Jeanie Bourke - RE: 50 Danforth St., BP#2014-02307 Plan review comments

The following is a list of required details in order to proceed with the review of this permit application:

DRAWING NUMBER
A1.10

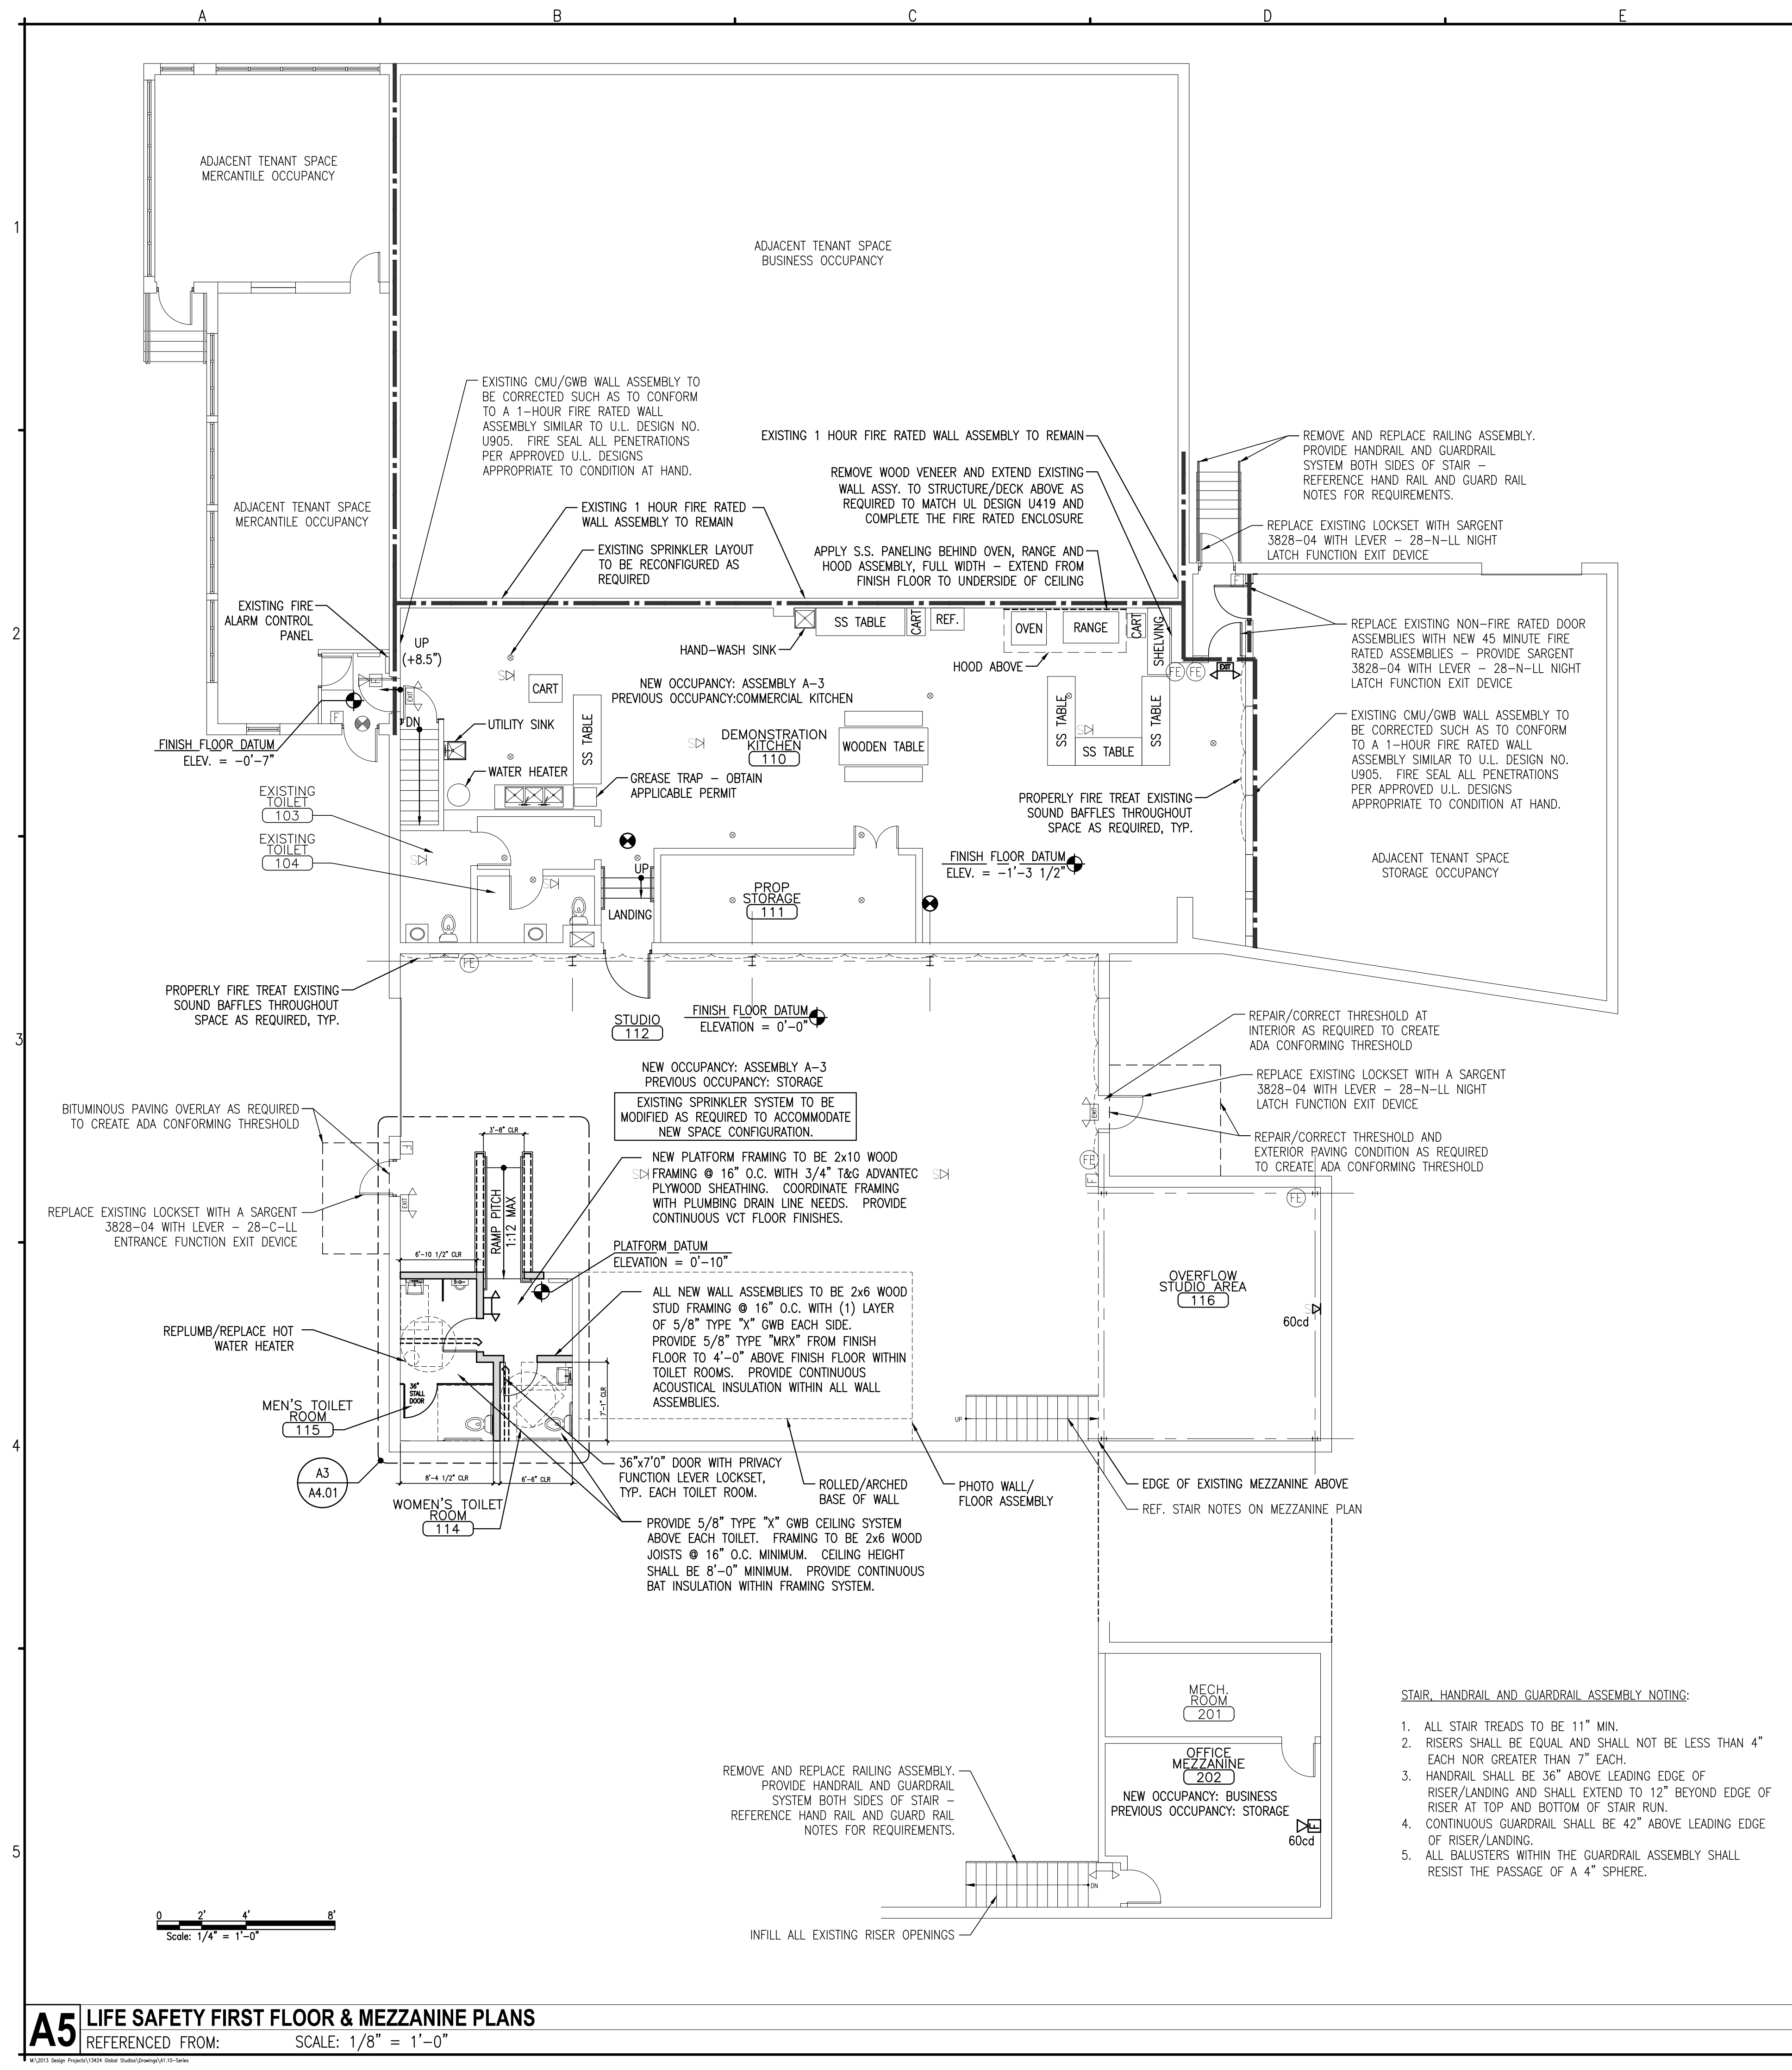
2. A complete floor plan which delineates all the use and occupancy areas, including the full kitchen fixture and equipment layout and other areas that may have equipment, dividers, etc. The submitted plan shows many dashed lines for walls, doors and stairs. This typically indicates removal or demolition of said items, but the project description only includes work for the hood suppression and grease trap. Stairs should be provided with directional information, ie. up or down and plans for all levels of the areas used including mezzanines need to be included.

The plan submitted shows an adjacent tenant, however it appears there is no demising wall between the spaces, please address.
